Reference No:	2021/62/94082/W
Site Address:	26, Stratford Close, Golcar, Huddersfield, HD7 4BU
Description:	Erection of front dormer extensions with side single storey and first floor extensions and new porch enclosure
Recommending Officer:	Tom Hunt

DECISION – Full Conditional Permission

Officer Report

2021/94082 – 26, Stratford Close, Golcar, Huddersfield, HD7 4BU

Client
MR & MRS C HINCHLIFFE
Project title
PROPOSED FRONT SIDE AND DORMER
EXTENSION
Project Address
26 STRATFORD CLOSE, GOLCAR,
HUDDERSFIELD HD7 4BU
Drawing title
PROPOSED ELEVATIONS
Scale @ A1
1 : 50
Project No.
2021-1497-P300

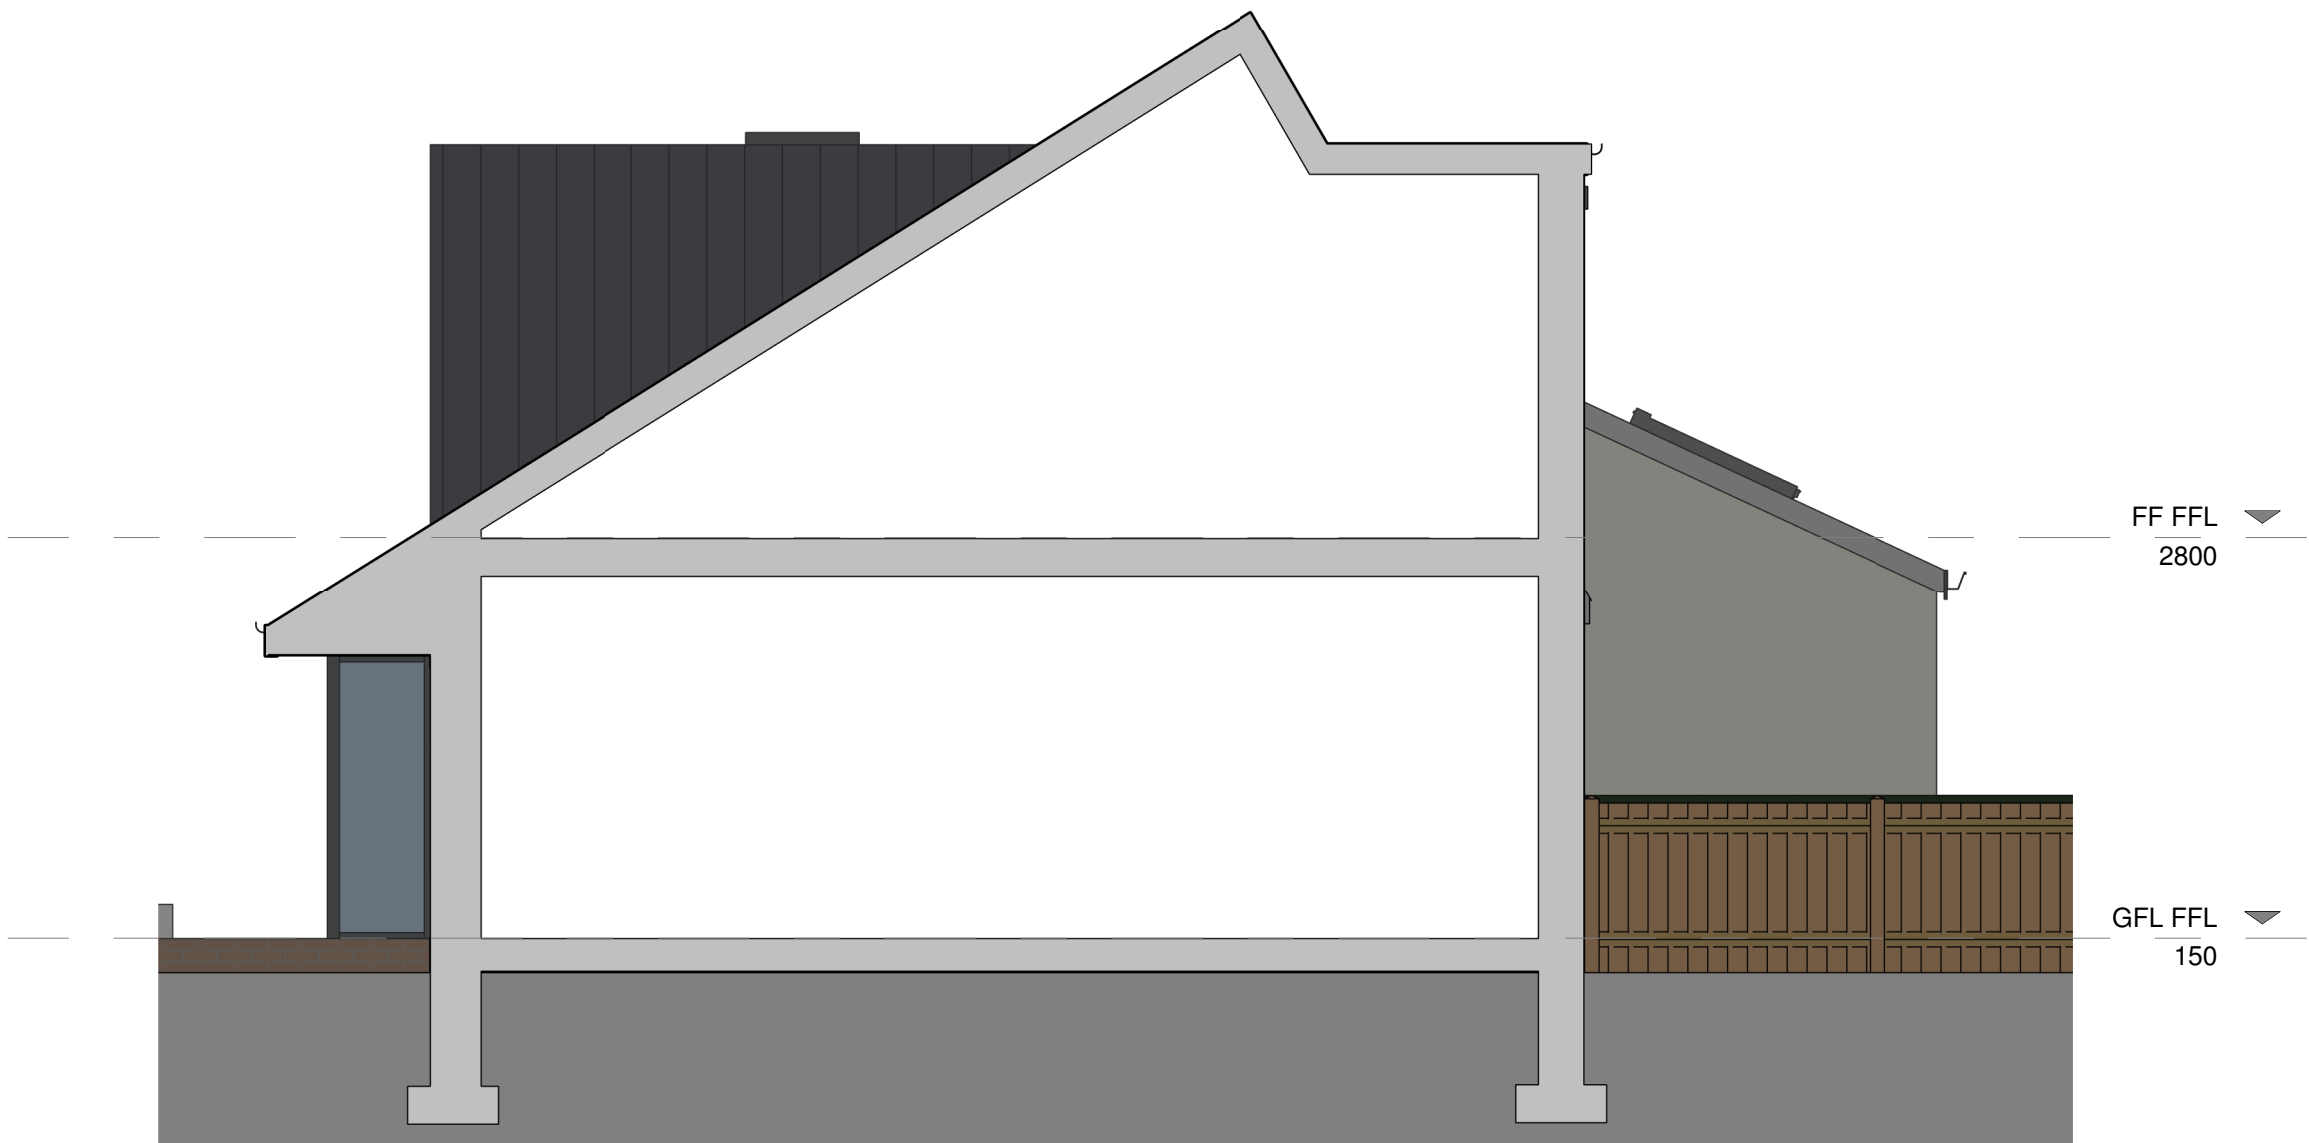
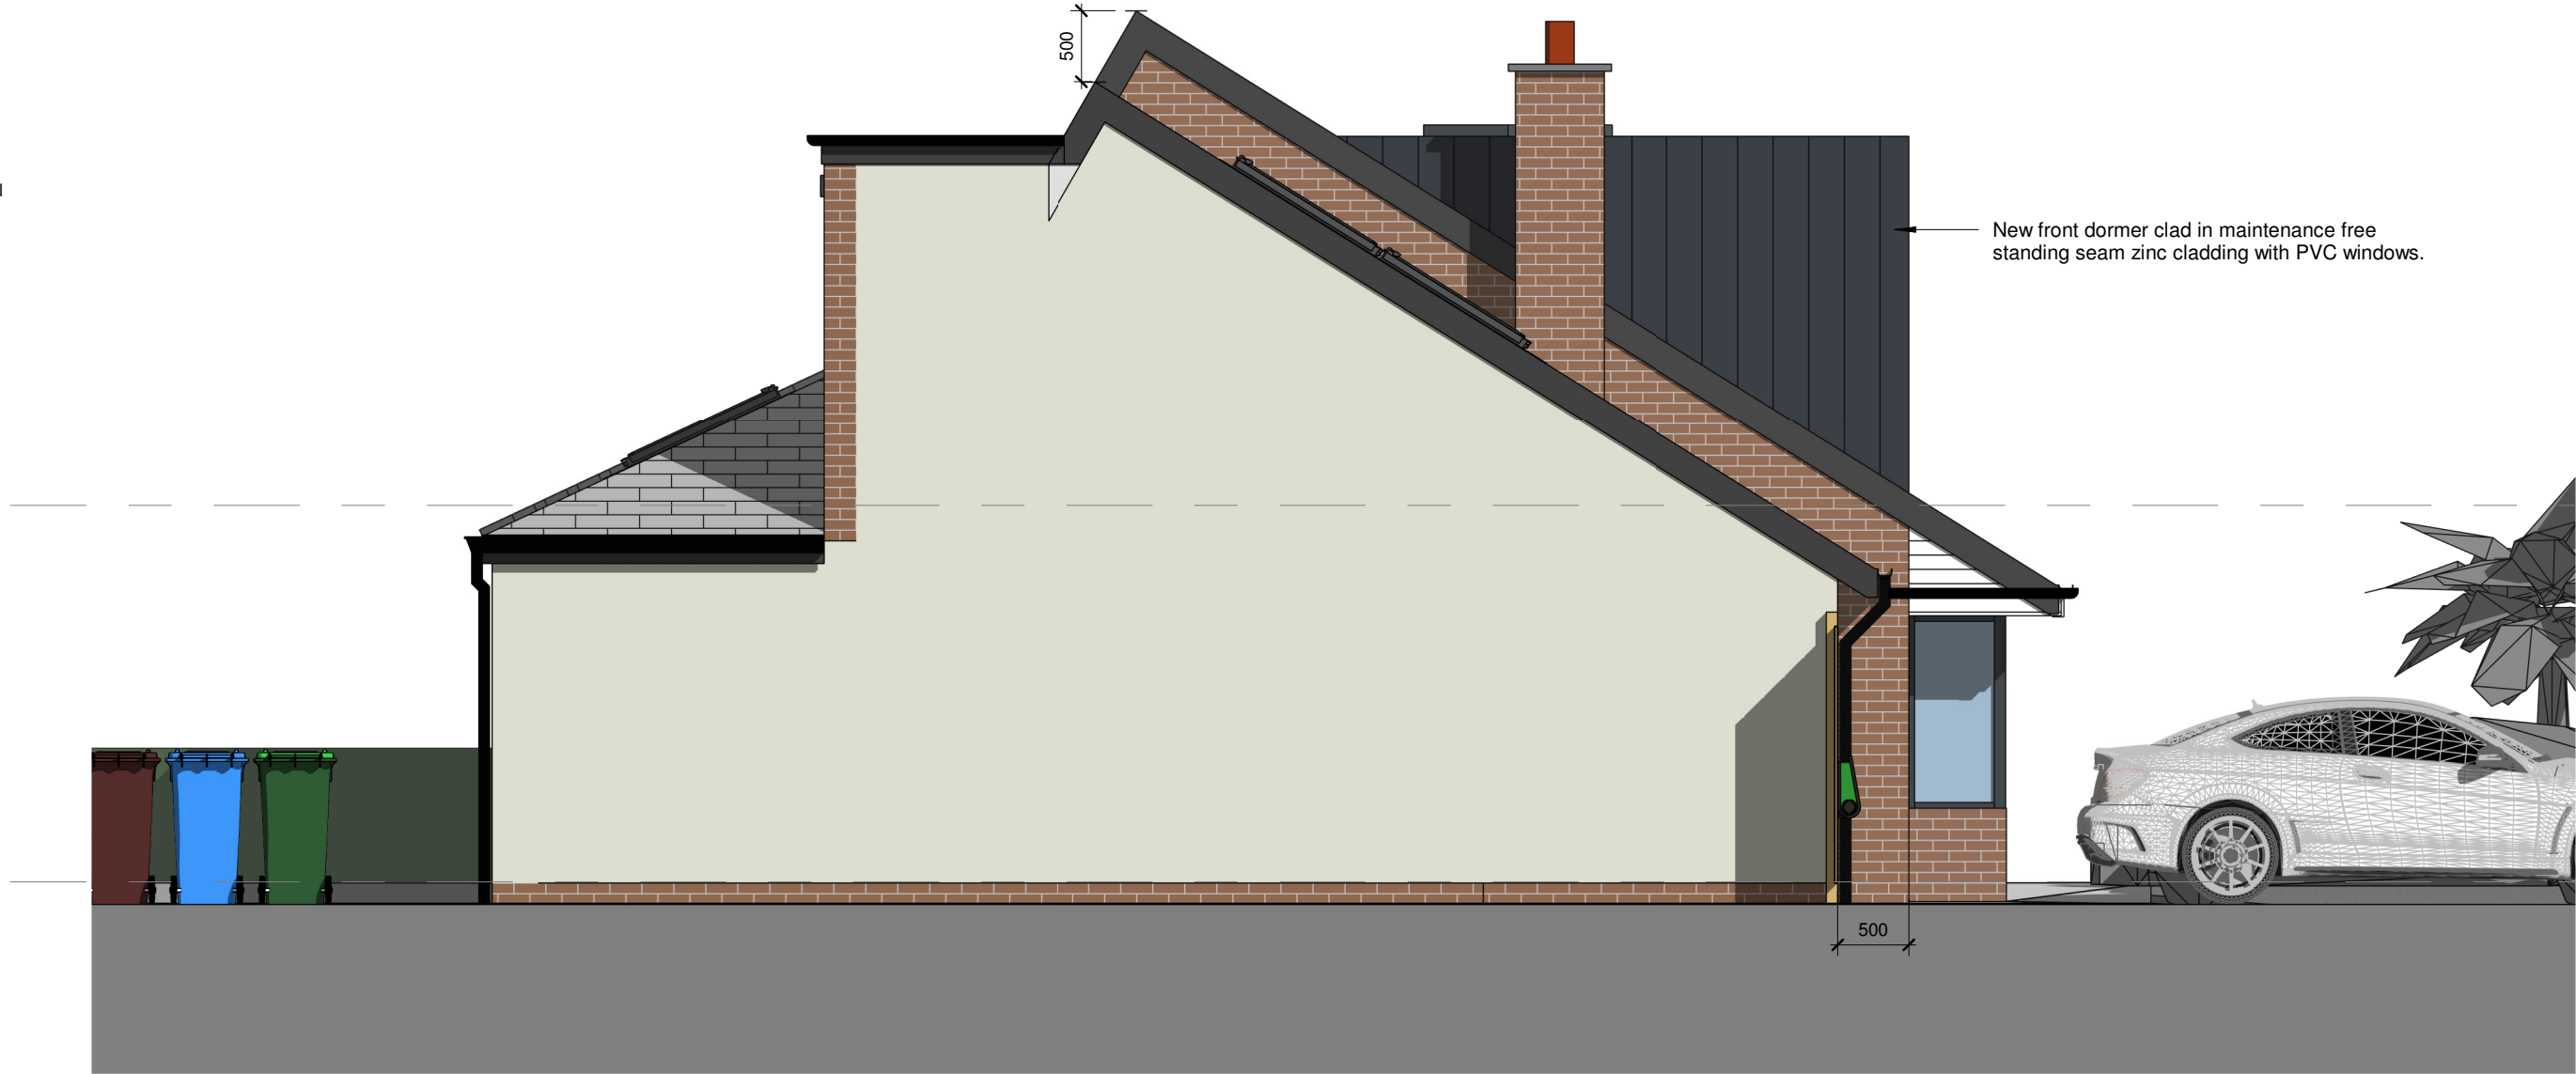
The proposed flat roofed dormer extension would have the dimensions of:
4m projection from the front roof elevation x 5.798m width x 2.5m height with a set back from eaves at 1.25m approximately. It would, at the front elevation, have a recess wherein windows would be placed. This would be clad in standing seam zinc cladding with PVC windows of which only face to the highway and not to the side elevations walls. There would be two rooflights within the dormer roof.

This would be set back 0.5 from the primary elevation of the host. It would have a roof profile to its primary elevation and to its rear, present as a flat roofed first floor extension. The roof ridge height would be 5.78m approximately and be set down from the host by 0.5m, the eaves height would have an increased height of 2.3m to the host eaves of 2.2m to the primary elevation. There would be a vertically orientated double window close to the roof ridge height at the front to be obscurely glazed. This would serve an ensuite (non-habitable room).

At the rear, the flat roof would be stepped down 0.4m at a sharp angle to meet a flat roof height of 5.4m from ground level. This would project 1.65m from the roof plane and be 2.432m width adjoining the host's first floor extension's elevation at the rear. This would have a window to the rear serving a wardrobe room (non-habitable room).

The side extensions would be set down from the host roof ridge height and to have most of its bulk and massing restricted to the rear. The design of the roof to the front would harmonise well with the existing roof. The originally proposed front dormer would have added too much massing overall in conjunction with the main front dormer and it is considered that the rooflights would serve to be a minor alteration to the roof and to the street scene rendering it to be acceptable. The first-floor extension to the rear would harmonise with the rear first floor extensions and be mainly screened from the streetscene by its roof at the primary elevation and additionally screened by the bulk and massing of its neighbour to the southwest. The materials would be to mostly match the host building with use of concrete tile, dark PVC framing and red brick. The use of white or cream render to the small scale side extension at the primary elevation would match the current side extension being a small scale change in the streetscene's palette of materials and be acceptable.
